From: Contact Centre (CRM) <contact@ribblevalley.gov.uk>
Sent: 06 February 2022 16:25
To: Web Development; Planning
Subject: Planning Application Comments - 3/2021/1262

Planning Application Reference No.: 3/2021/1262

Address of Development: William Pye Chapel Hill site Longridge

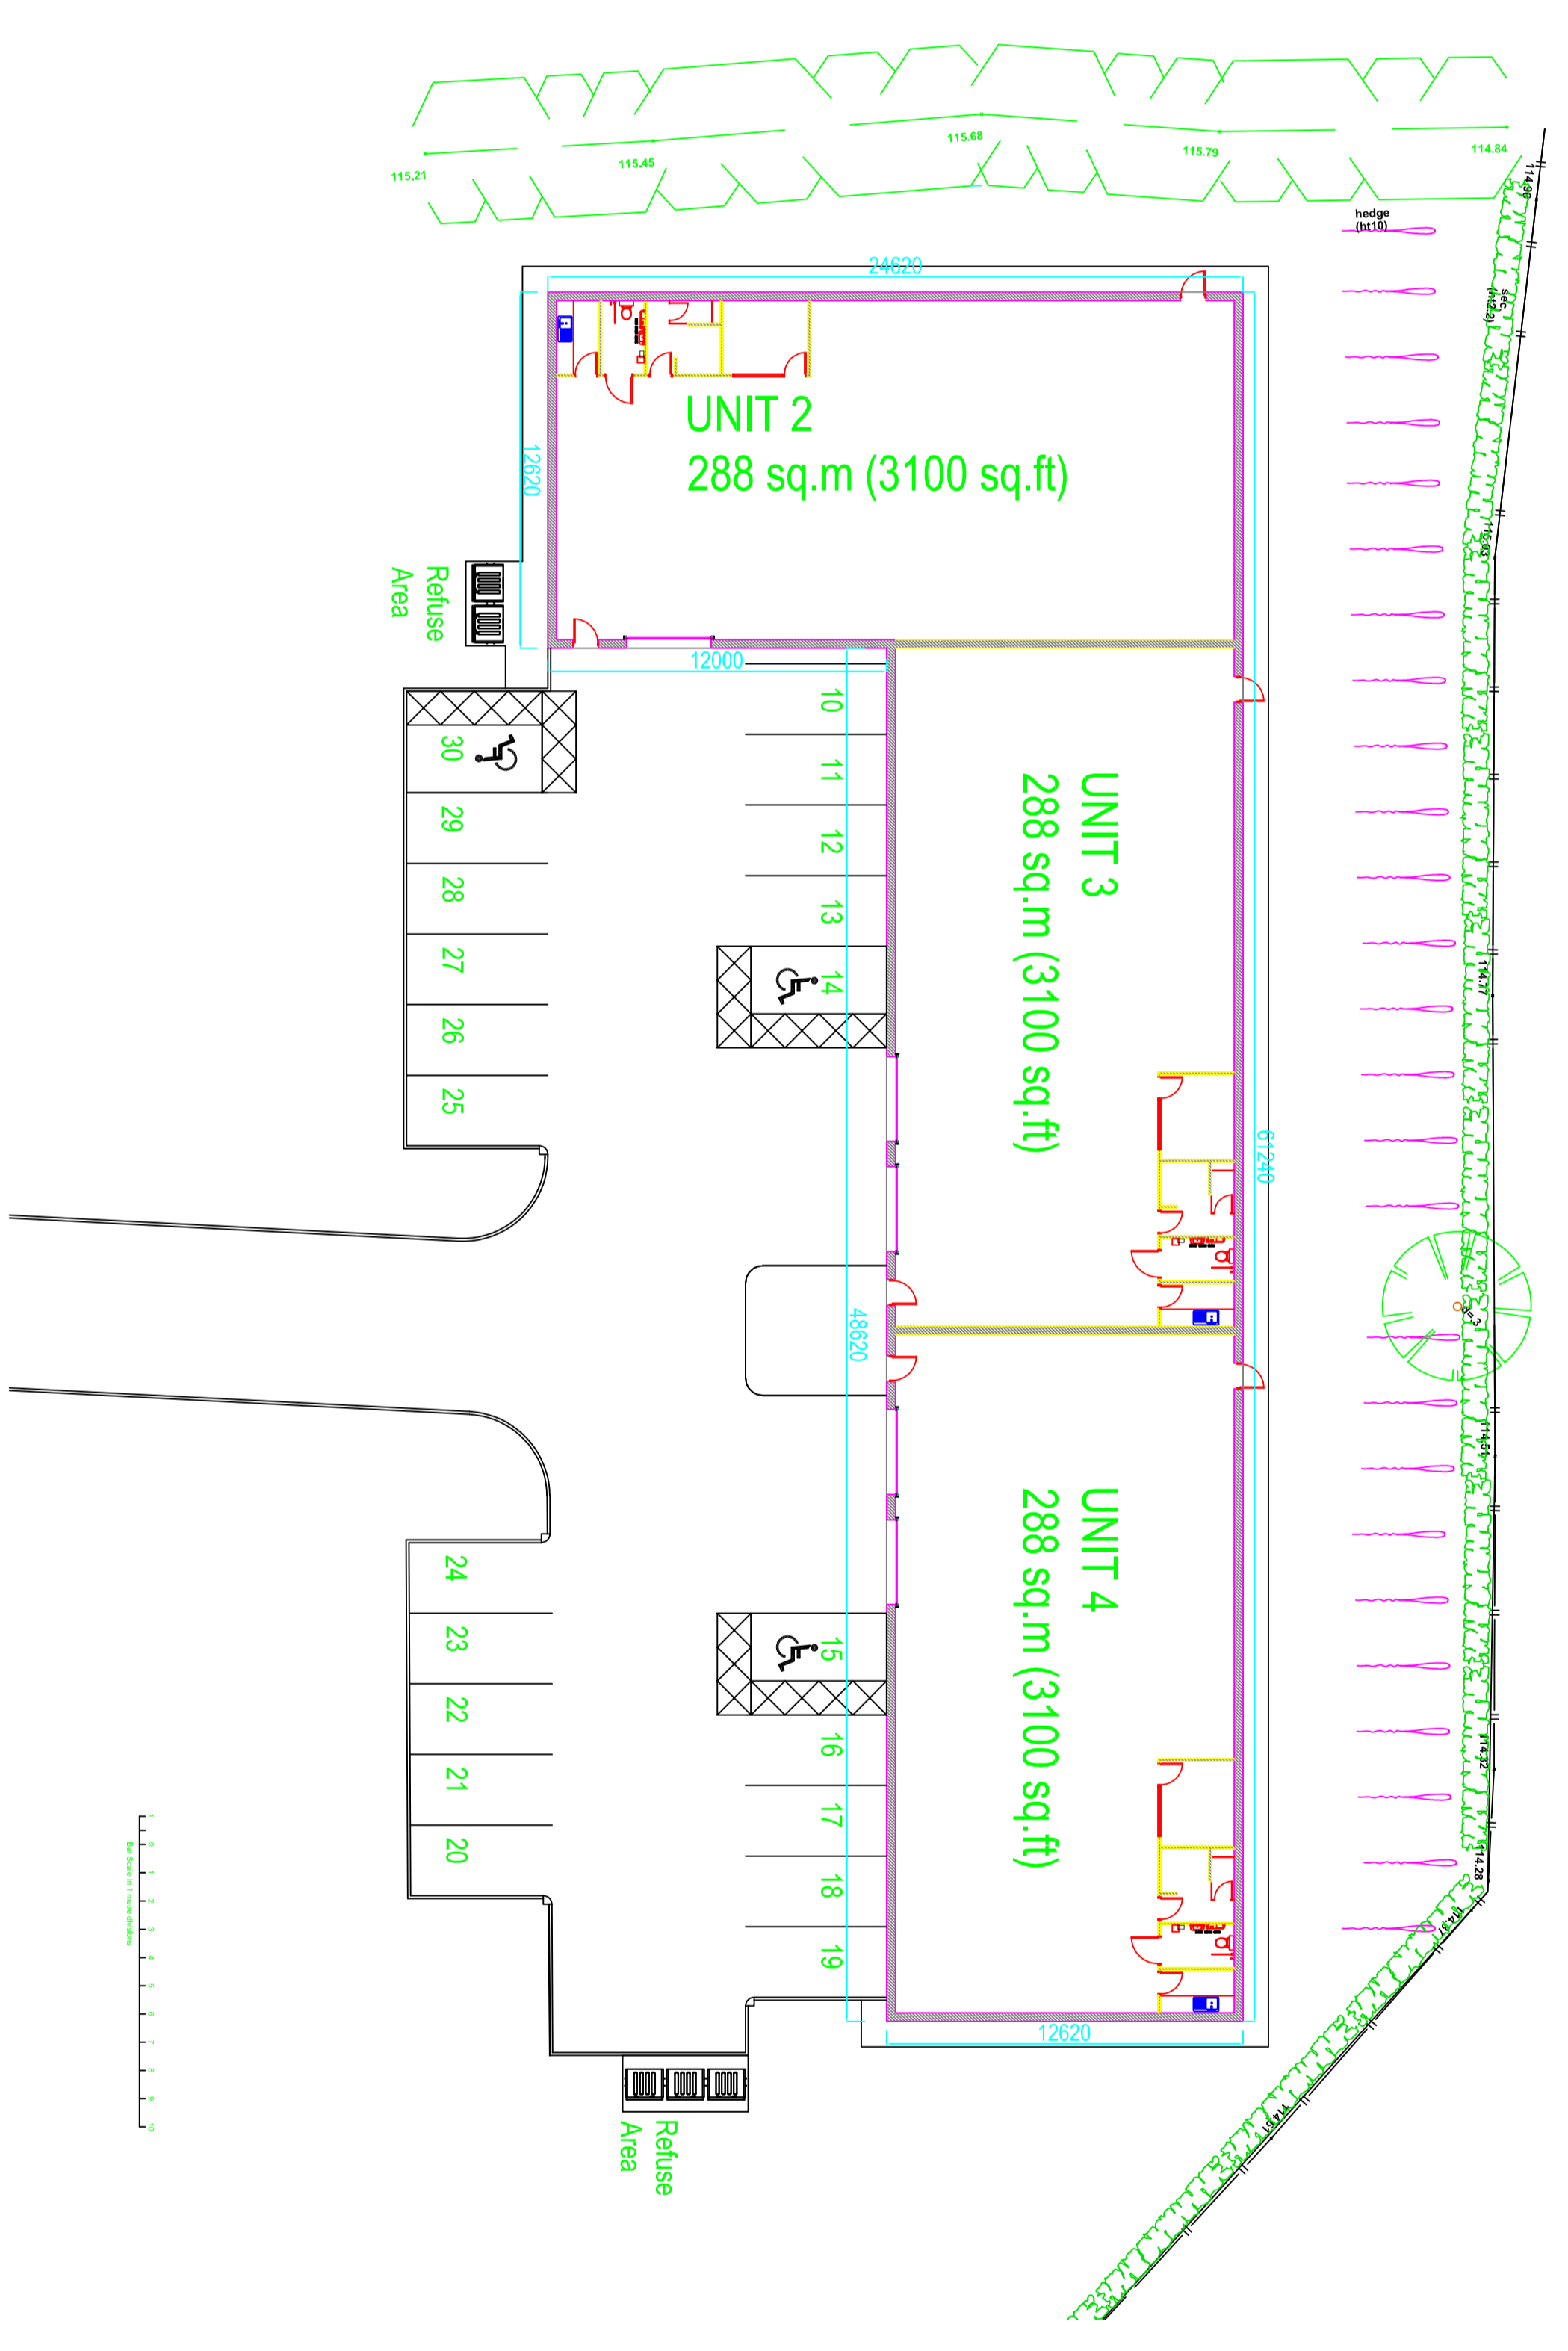
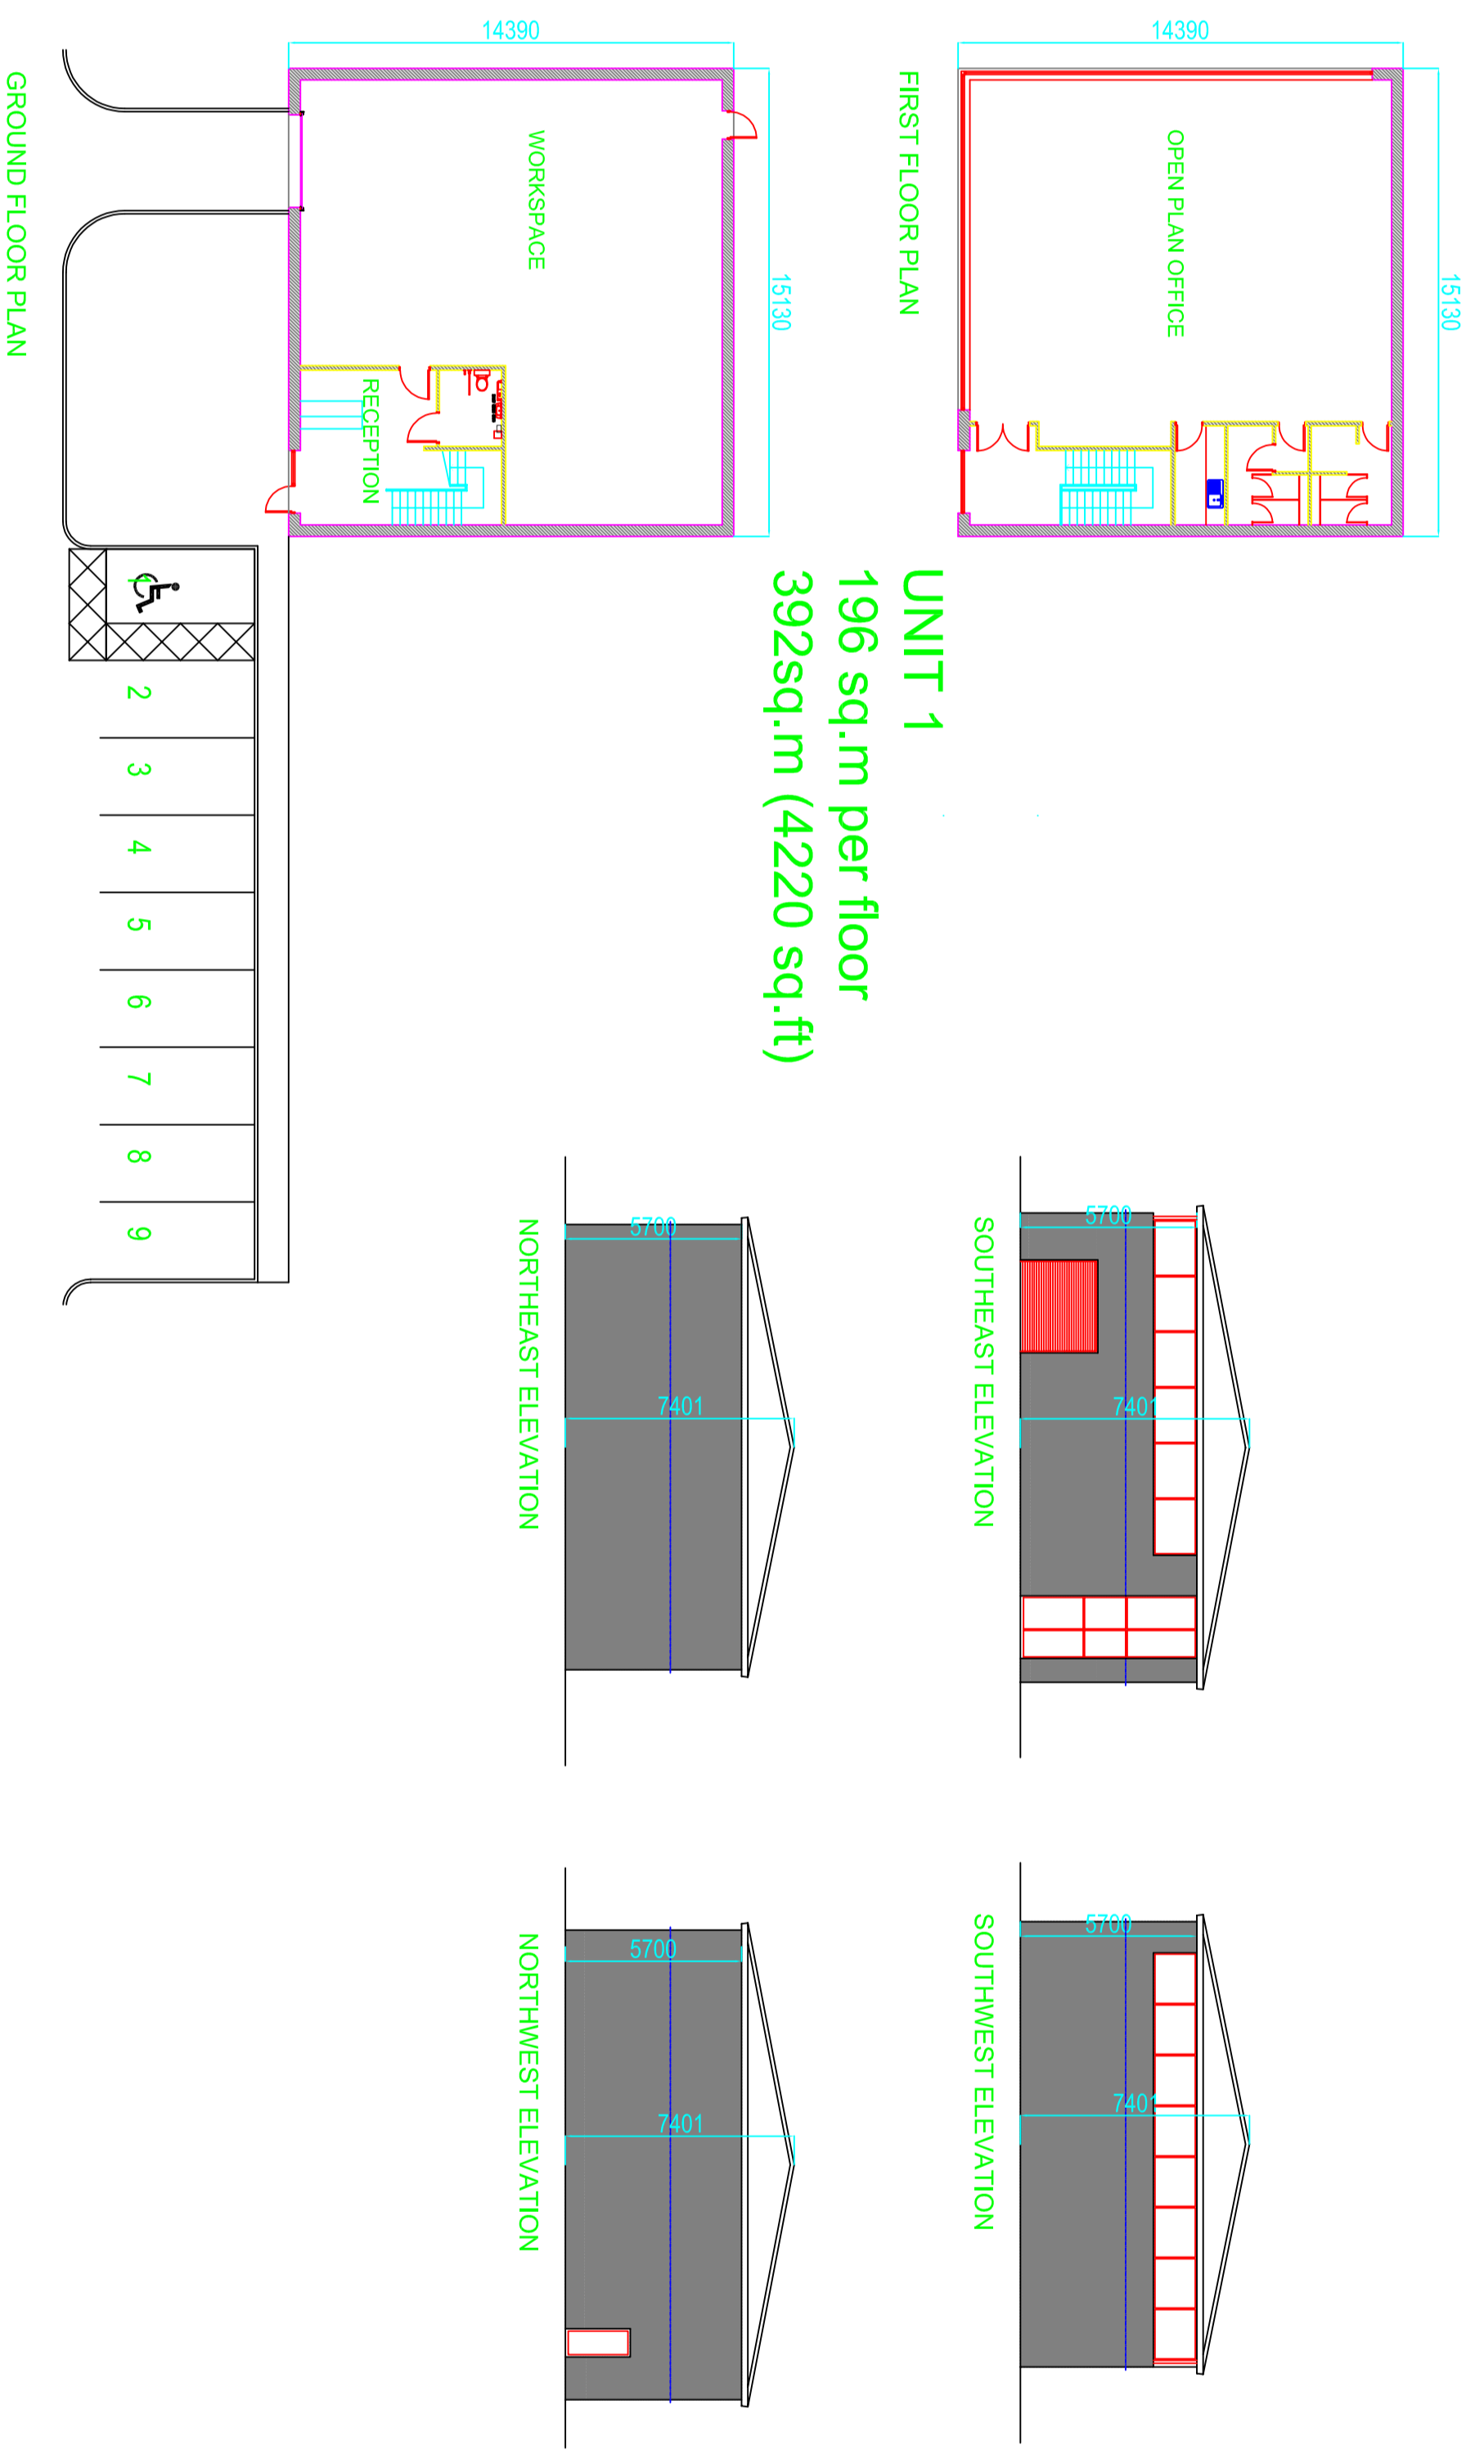
The plan shows the floor level of the proposed building as lower than the floor plan of the houses. The planning documents say the level will be at the floor level of the houses or 'slightly higher'. If this is the case, the plan is misleading as the height of the building will be higher than shown

the building could be built lower than shown on the plan so less intrusive on the houses nearby

Why is there just a hedge proposed behind the building and not trees like the other side

I have concerns over the height of the proposed building and the [REDACTED]
